Submission in response to 2<sup>nd</sup> amended application for SSD 7056.

Please read this submission as well as those I have already submitted in response to the applicant's original (November 2015) and amended proposal (May 2016) with the exception of points made about the now abandoned plans to construct a 'glass box on stilts' alongside Campbell's Stores.

Figure 1 – Extract of Bay 12 Site Plan (Figure 1, Pg. 5, SSD 7056: Response to Submissions, Urbis)

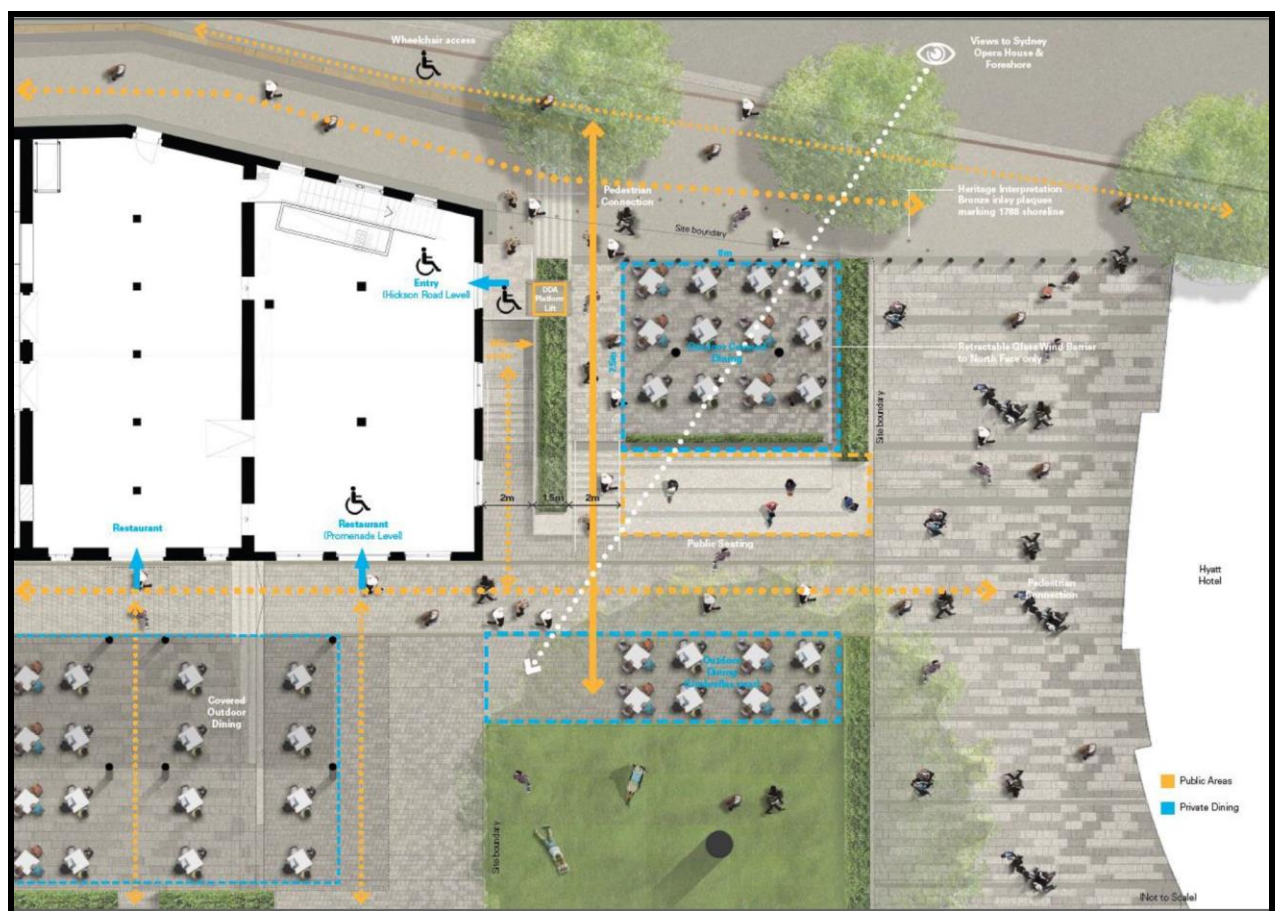
There has been no assessment of the noise impact of outdoor dining. The applicants propose a vastly increased outdoor dining area (double the existing) on the eastern façade of Campbell's Stores, outdoor dining in the centre of the western (Hickson Rd) façade and now additional outdoor dining for 50 people on the northern façade of Campbell's Stores and 60 people at the north-western corner – both fronting Hickson Road. Noise emissions in all four areas are of particular significance to residents at 8 Hickson Road. It is possible that outdoor dining noise on the eastern faced will have less of an impact, but in the absence of any valid assessment from the applicants' consultants, it is impossible to judge this accurately.

For the same reason, there should be no outdoor trading or functions permitted at the northern section of the Stores or along their western façade after 6 p.m.

- the restriction of operating hours to between 7.00 am and 11.00 pm indoors and 10.00 am to 8.00 pm in outdoor dining areas on the eastern façade and from 10 am to 6.00 pm in other outdoor dining areas.
